Application for Removal or Variation of a Condition following Grant of Planning Permission or  
 Listed Building Consent

Planning Permission - Erection of 2no. detached warehouse buildings divided into 3no. units to use under Class B8: Storage & Distribution of the Town & Country Planning (Use Classes) Order 1987 as amended, relocation of 4no. storage containers and provision of additional hardstanding area.

S/023/01858/18

Two

DRAWING No. 724/D/05	REV. C
--------------------------------	------------------

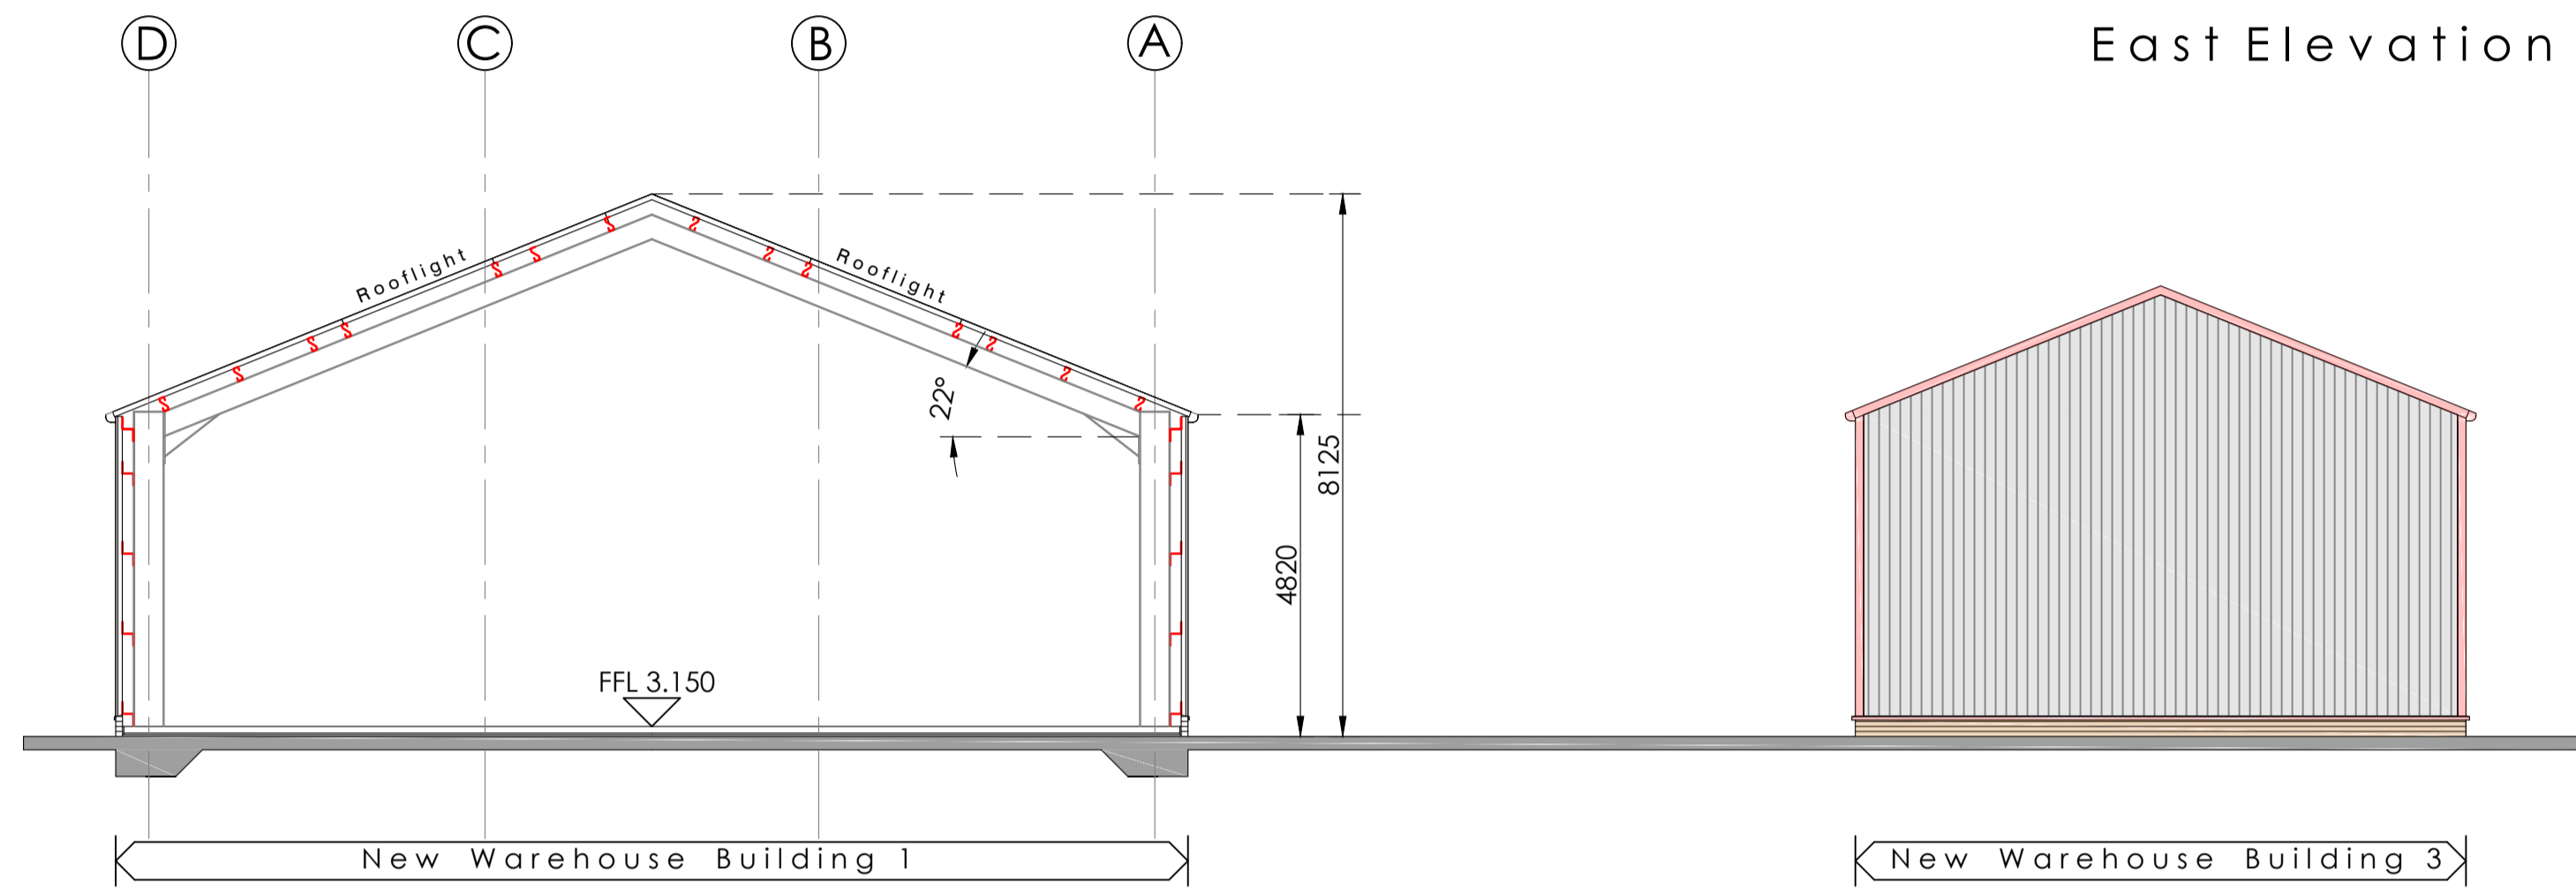
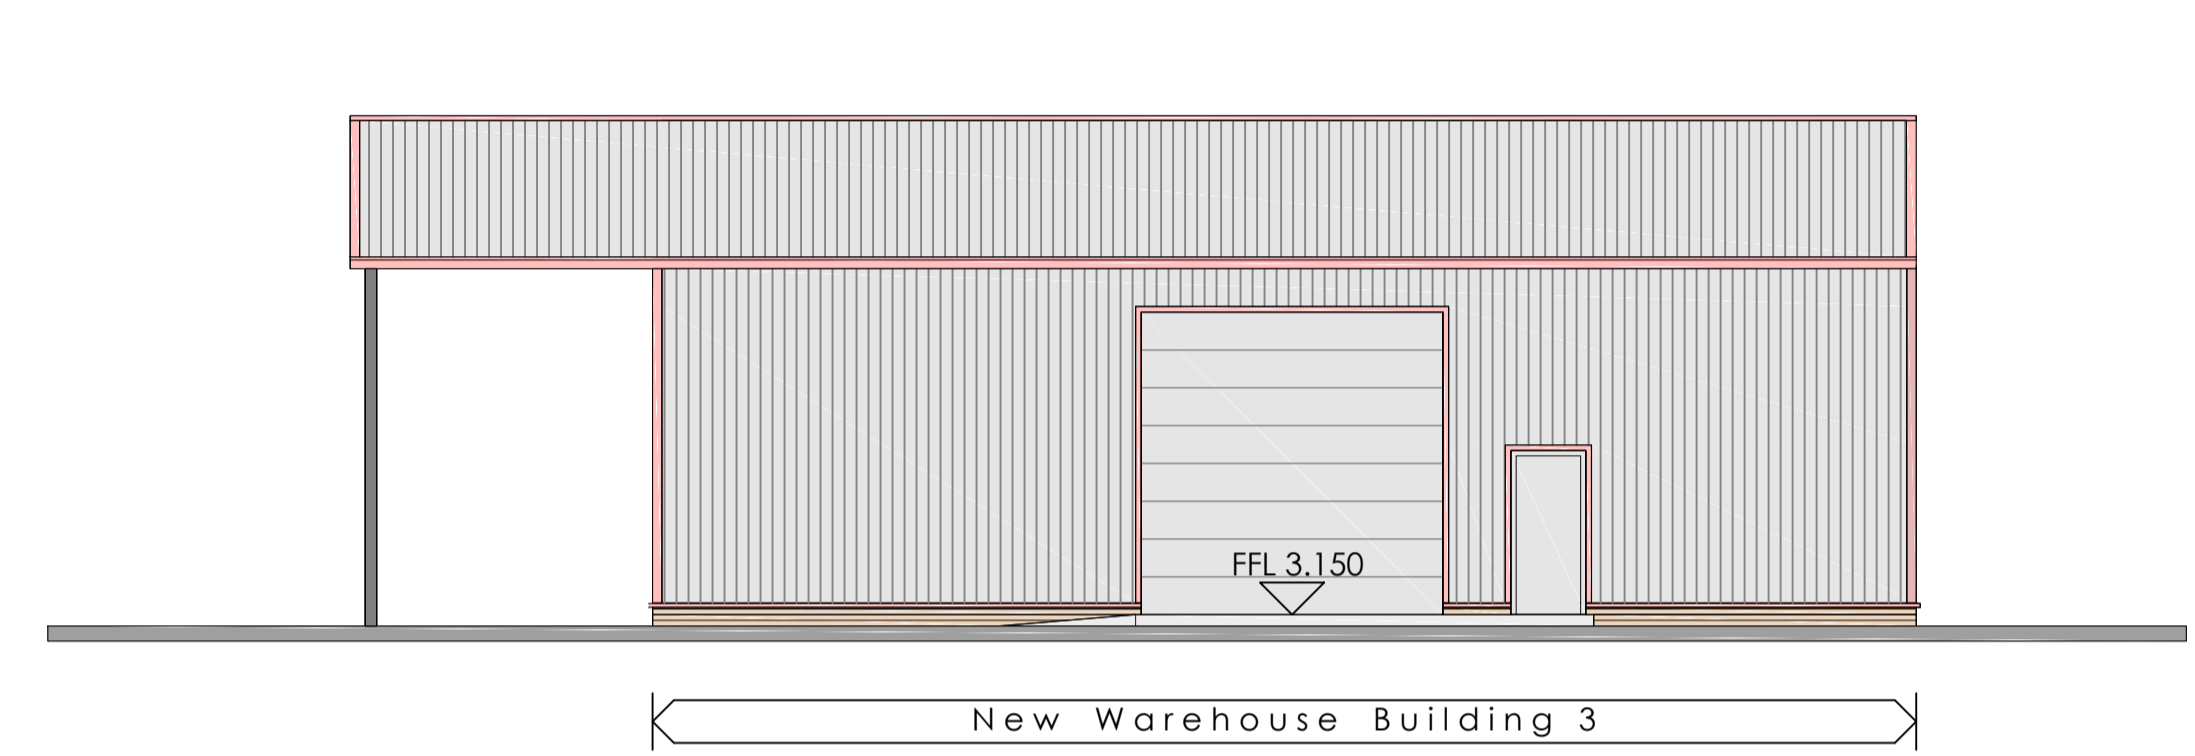
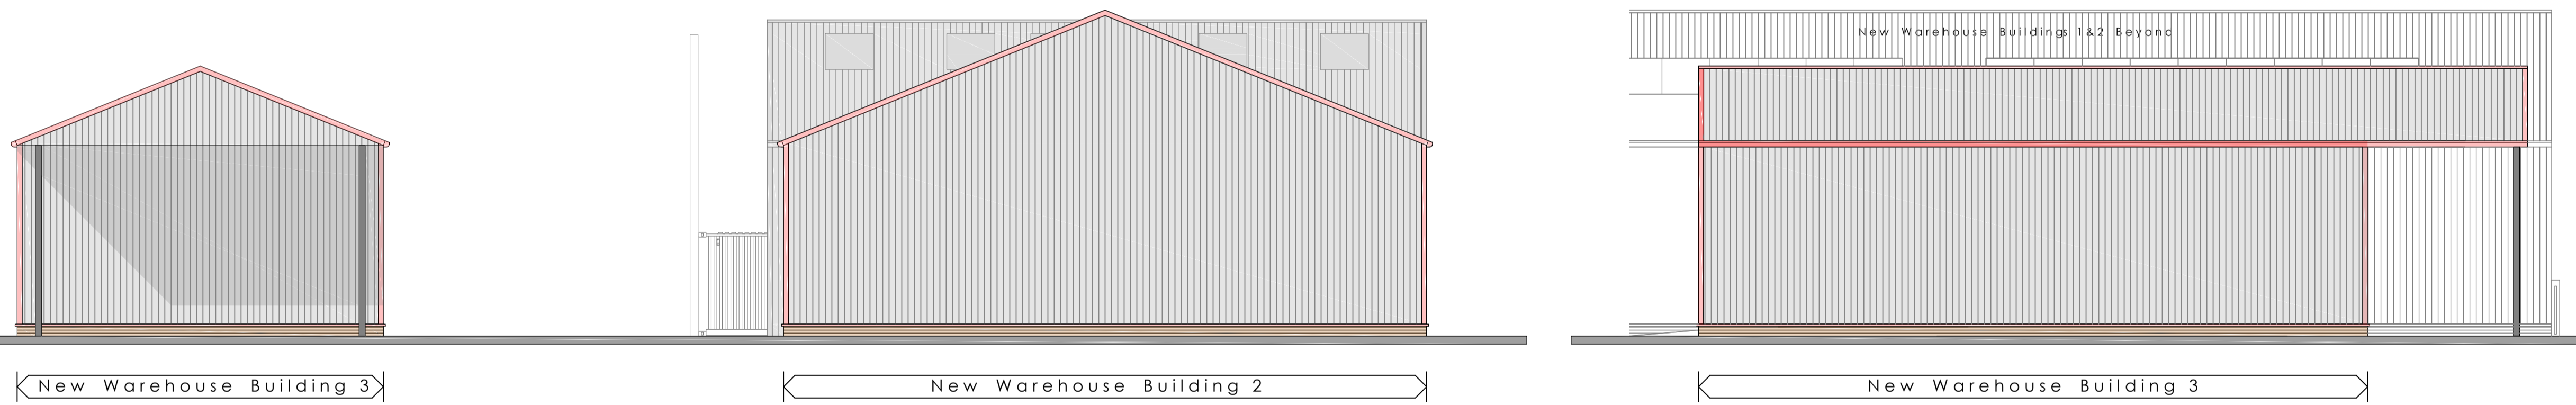
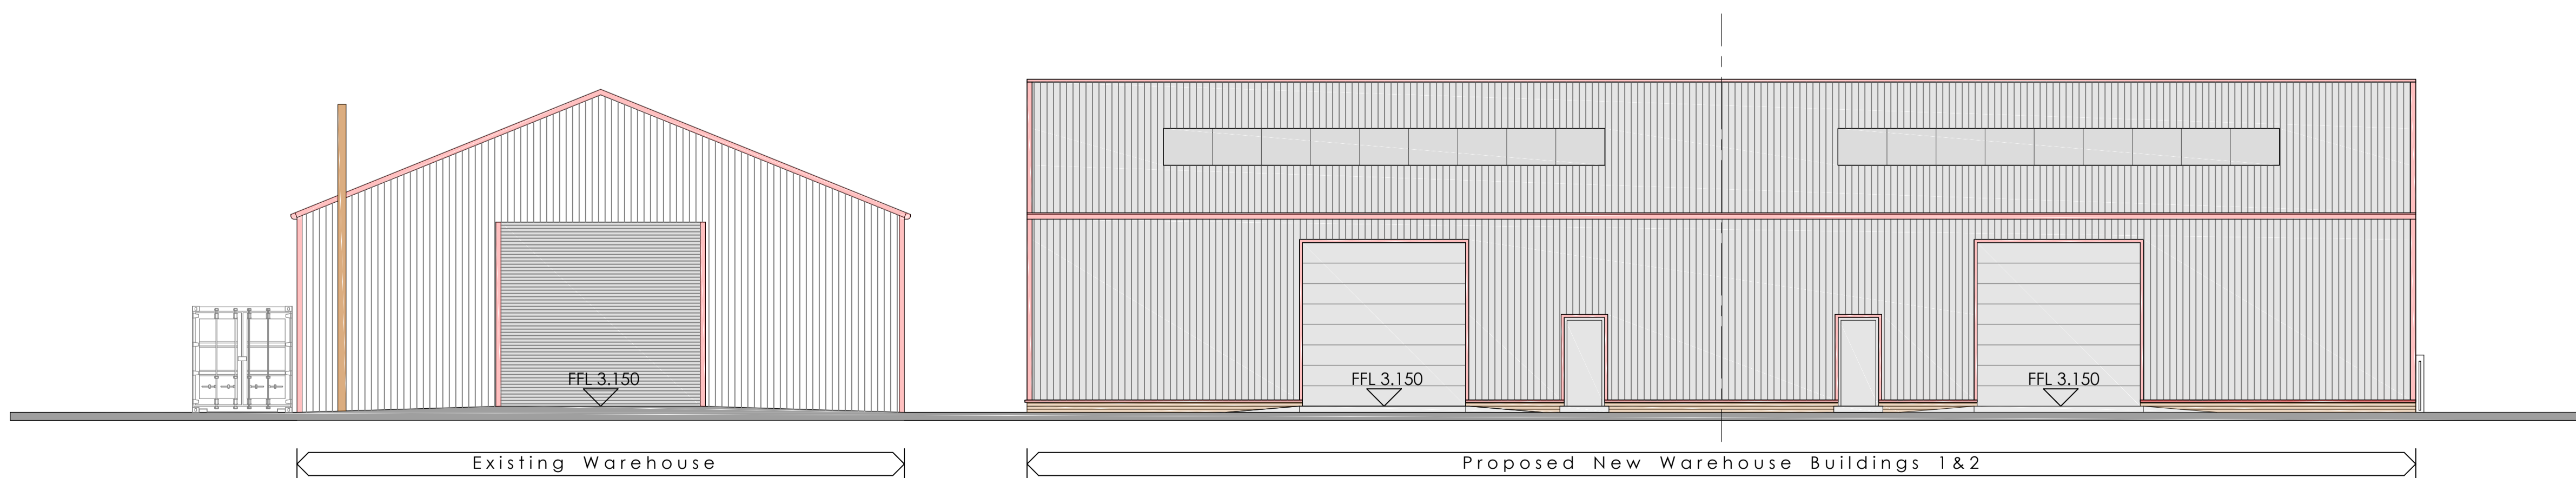
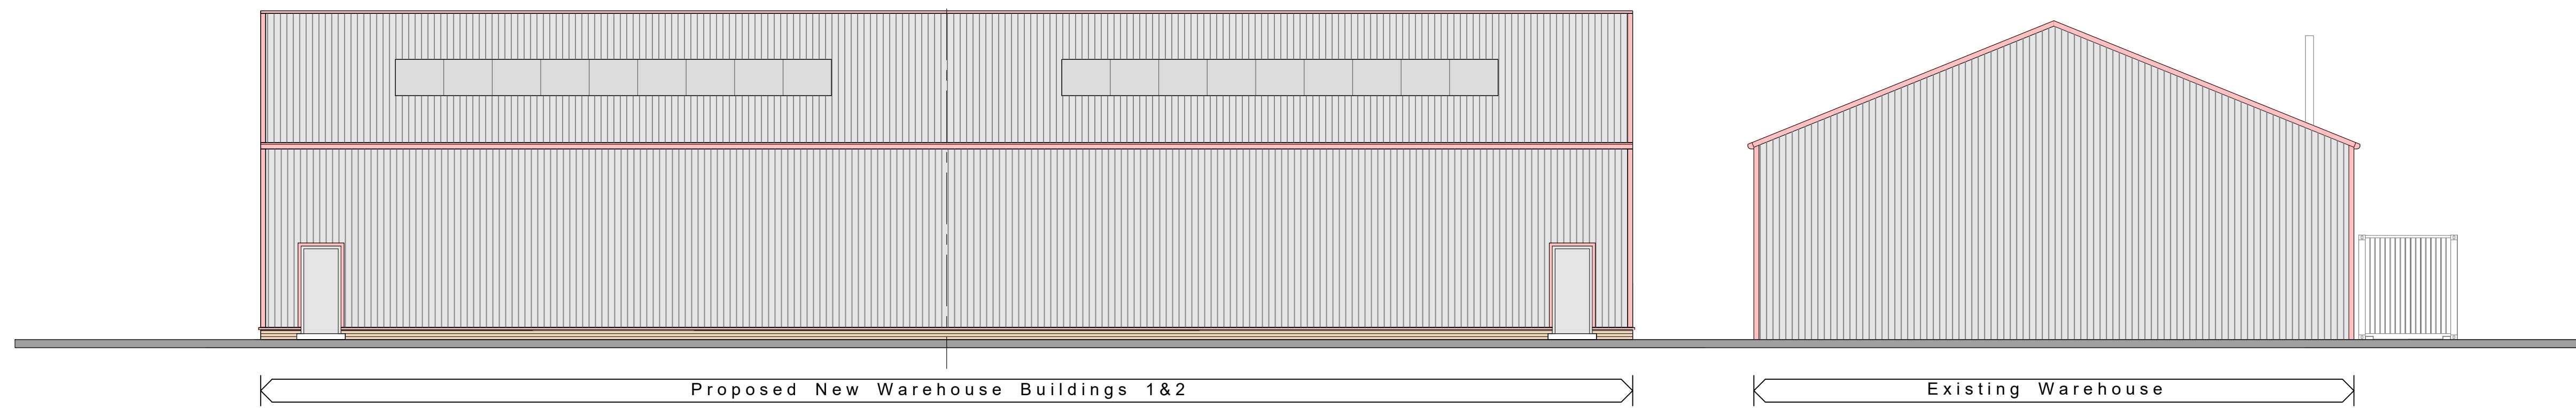
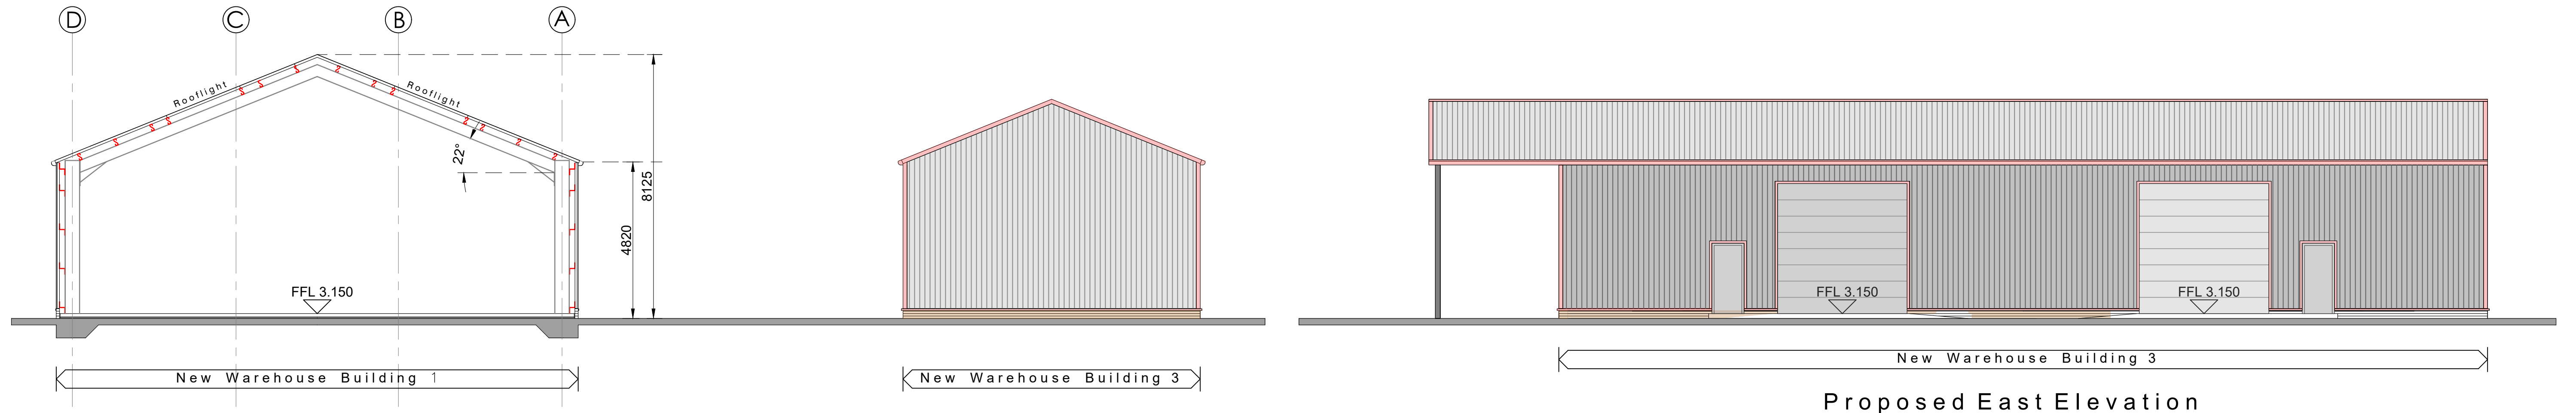
It is more practical and logistically more efficient to store goods in a single warehouse than a warehouse and 4 individual containers.

Delete the following approved plans;

Plan No. 664/D/05 Rev B Received by the LPA on the 17/09/2018

Plan No. 724/D/05 Rev C
